DRB ADMINISTRATIVE
SITE PLAN AMENDMENT
PROJECT NO. 10042246
APPLICATION NO. 1144
APPROVED 10/10/06
Patricia A. Johnson
Planning Director
DATE 1-27-12

SHEET NO:
A-1.0
SITE PLAN
NEW CONSTRUCTION
FILE NUMBER: 1144

PARADISE BAKERY & CAFE #610048
HOLLY PLAZA -
6550 HOLLY AVE. NE SUITE A-8
ALBUQUERQUE, NM 87113

APPLICATION #: 11AA 10106	PROJECT #: 1004246
PROJECT NAME: 6550 Holly Ave NE	
APPLICANT or AGENT: Tammy Korte	
PHONE # and E-MAIL: 314-415-2400 tkorte@arcv.com	
ZONE ATLAS PAGE: C-18	
ADMINISTRATIVE APPROVAL (AA) for:	EPC CASE DRB CASE

BAKERY CAFE:  
#610048  
SYSTEM: G3 (CALM)  
PROTOTYPE UPDATE: 2012

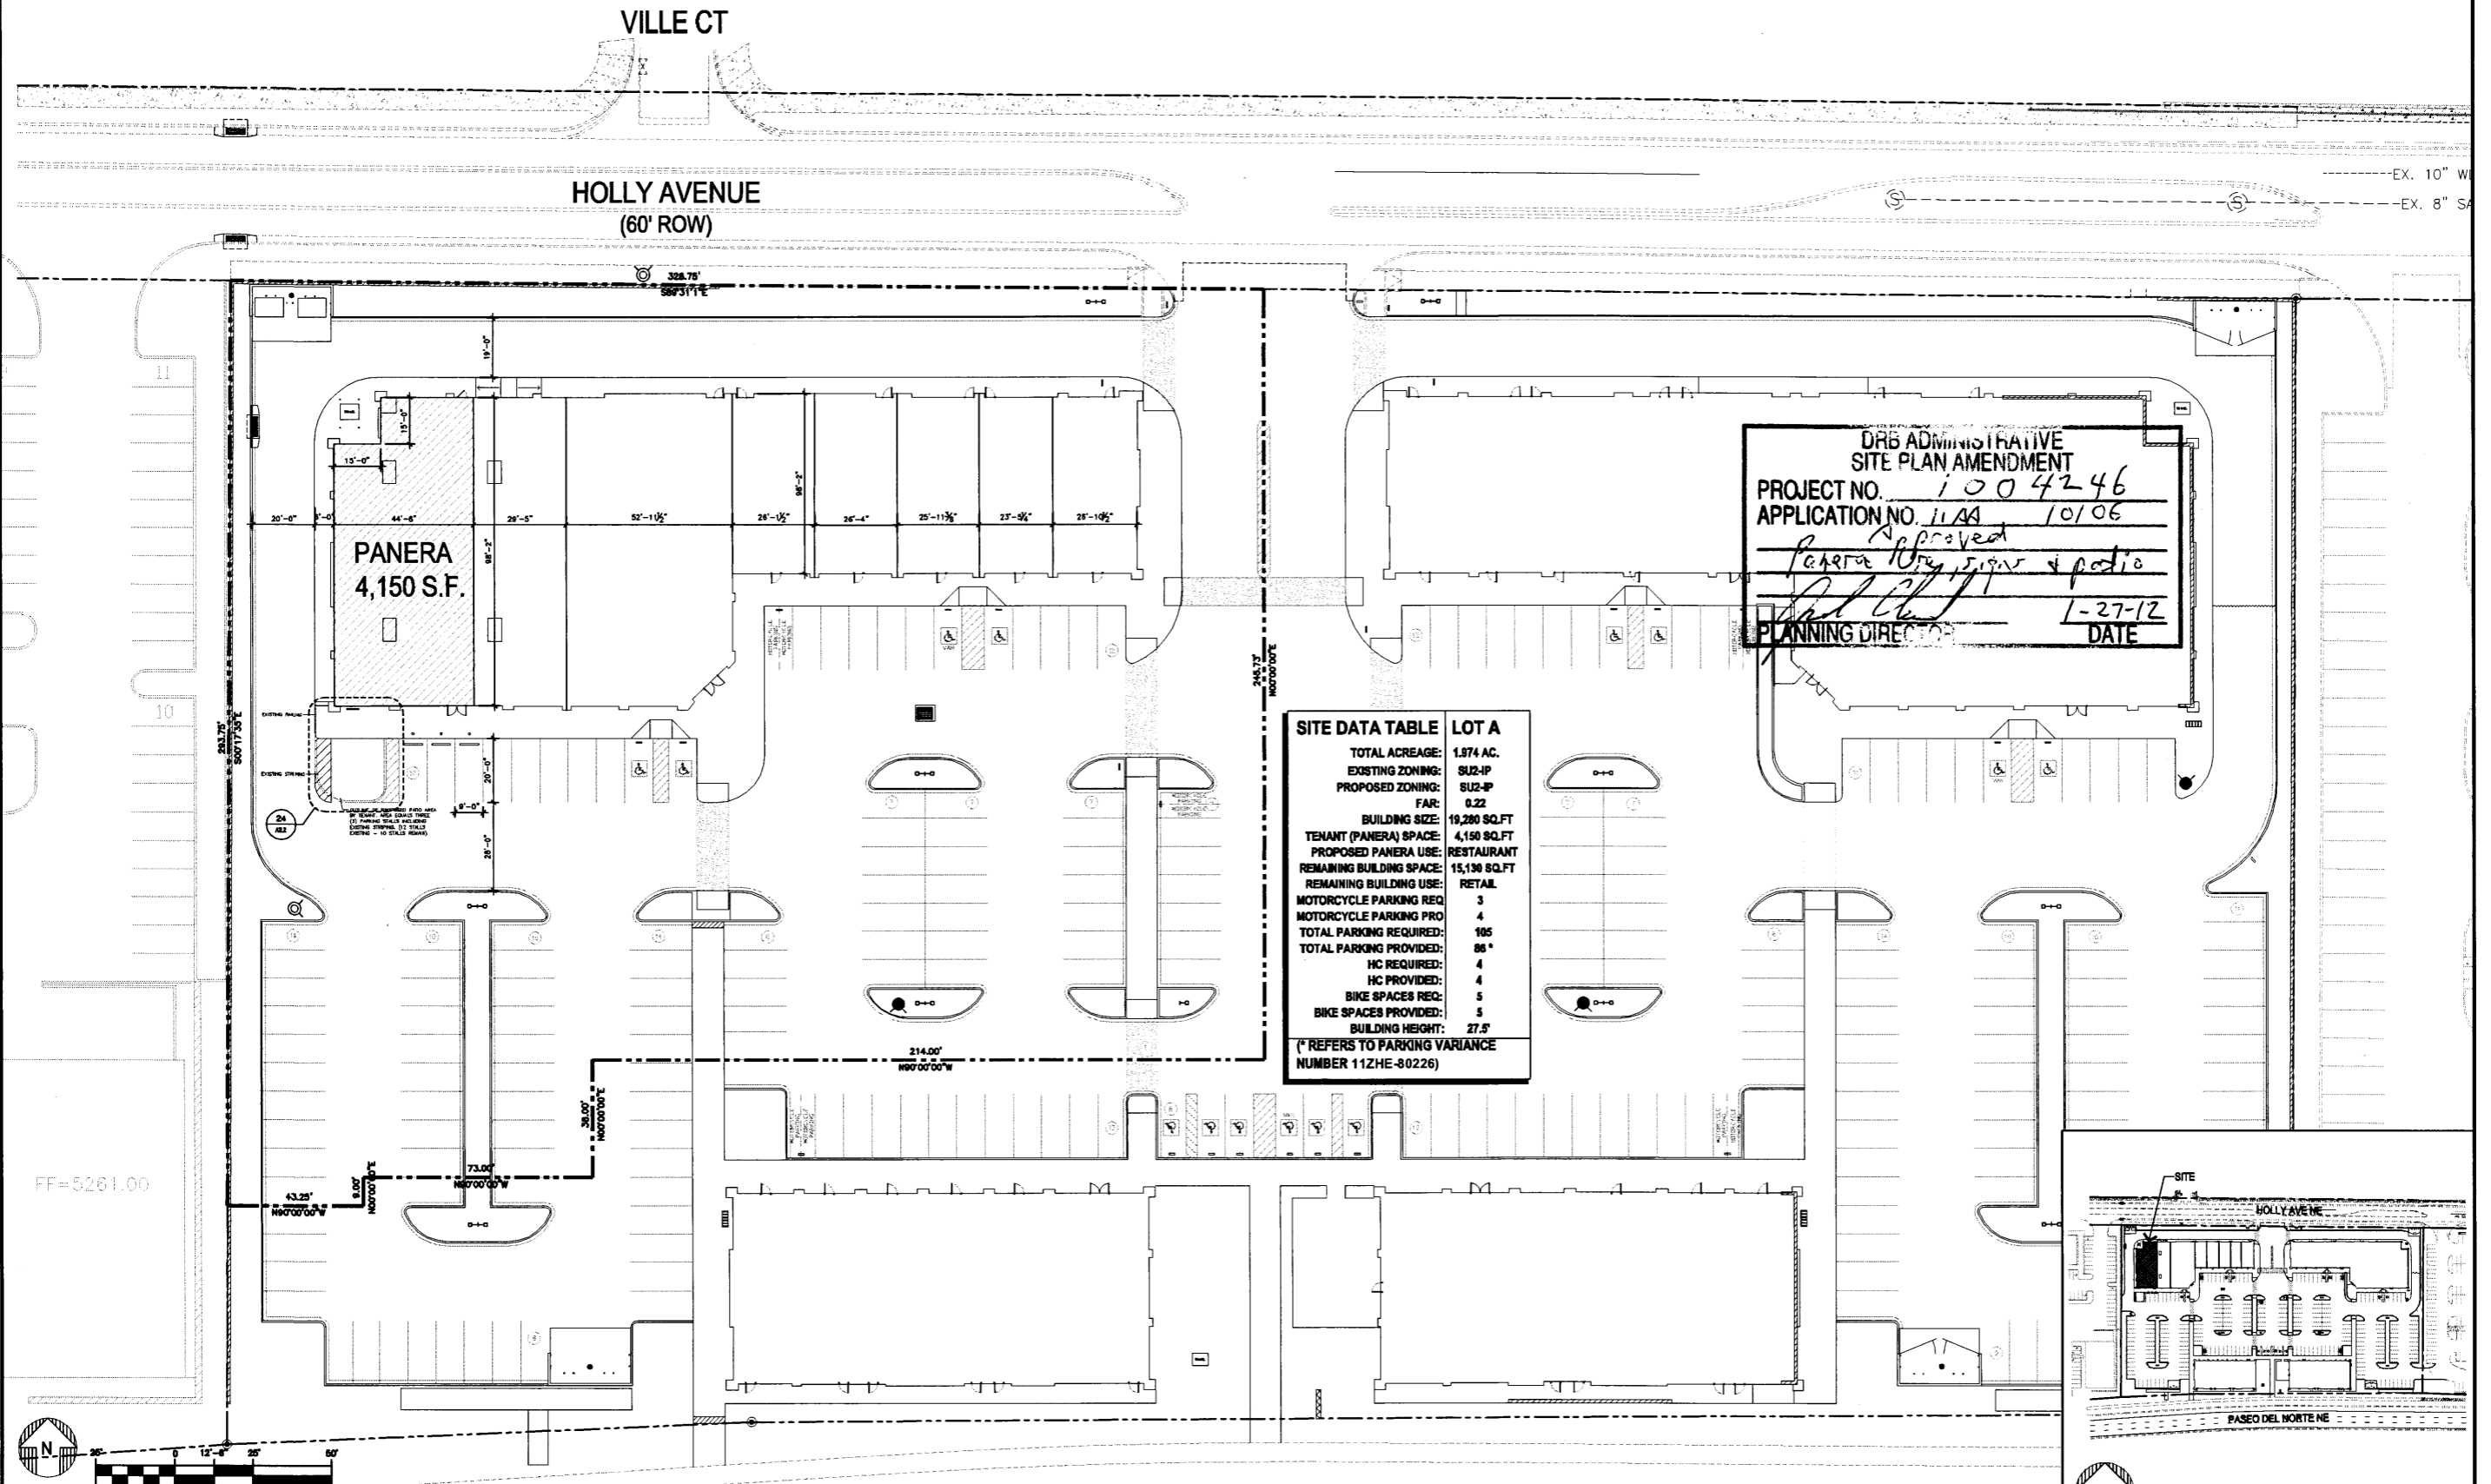
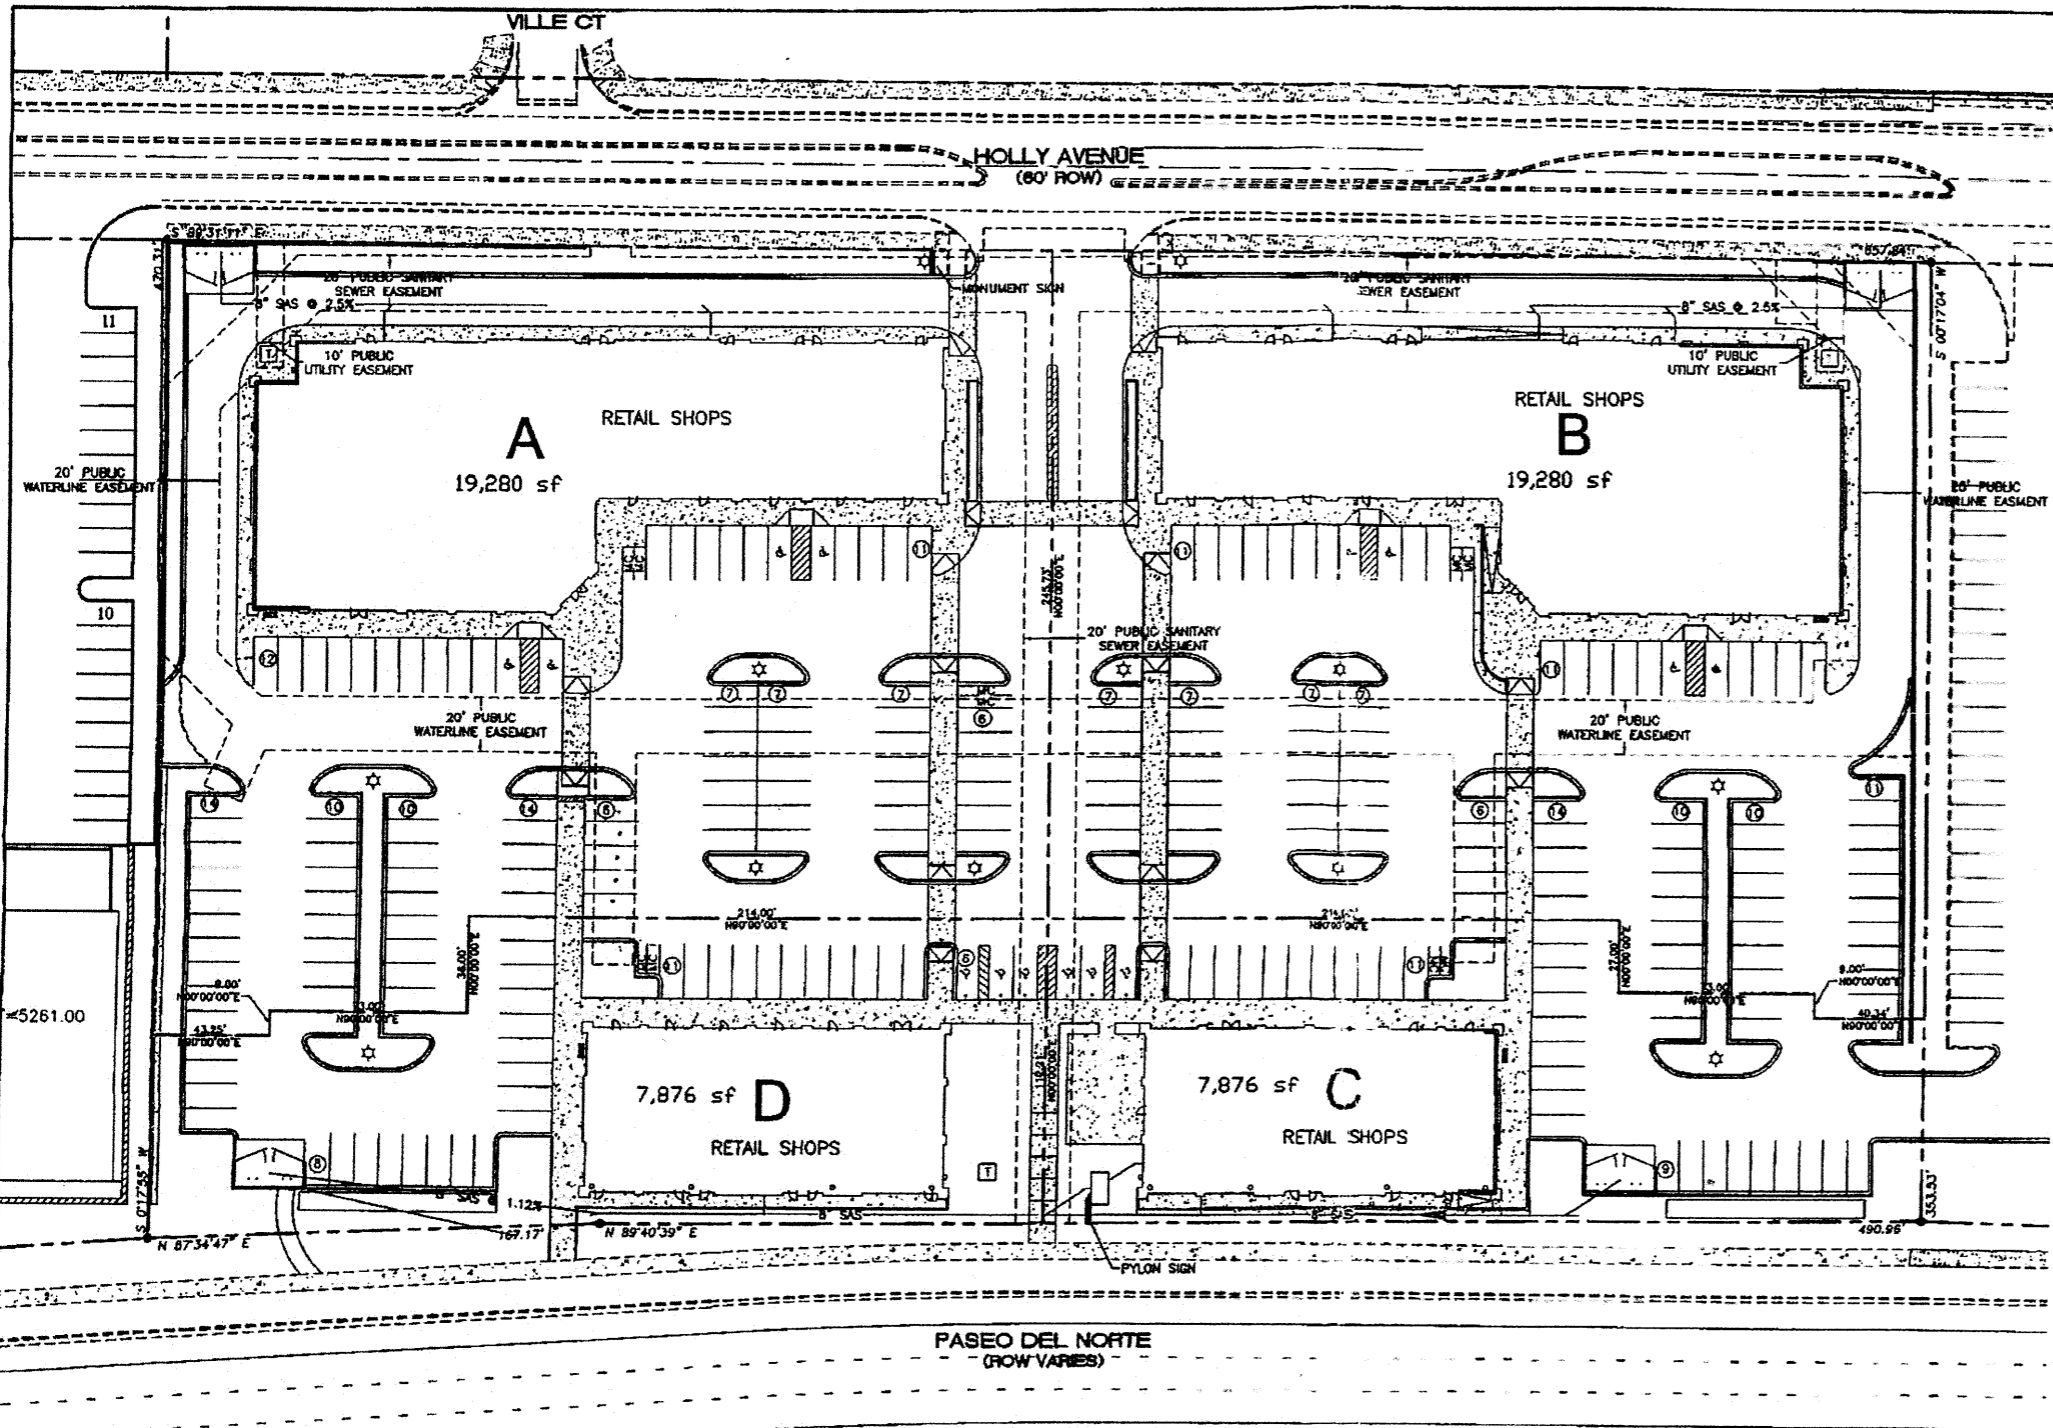
PLANS DISAPPROVED:	DATE: <i>07/08/11</i>	DATE:
PLANS APPROVED:	DATE: <i>08/10/11</i>	DATE:
COMMENTS: • NEED CORRESPONDENCE FROM TERRA WEST APPROXING/PERMISSION FOR USAGE OF THEIR SITE PLAN AS PART OF YOUR SUBMITTAL FOR BLDG PERMITS		
• PROVIDE GEOMETRY INFO FOR PROPOSED INFRASTR. W/IN PARKING AREA (W'S, L'S & R'S = 15' MIN)		
• NEED APPROVAL FROM NMDOT FOR PYLON SIGN ENCRACHING INTO THEIR ROW (AIR SPACE)		
• LOSS 2 PARKING SPACES: WILL THIS IMPACT OVERALL RPTD PARKING CALCULATIONS? VERIFY		
• WILL BE STAMPING THE SUBPLAN? ARCHITECT? SIGN/STAMP?
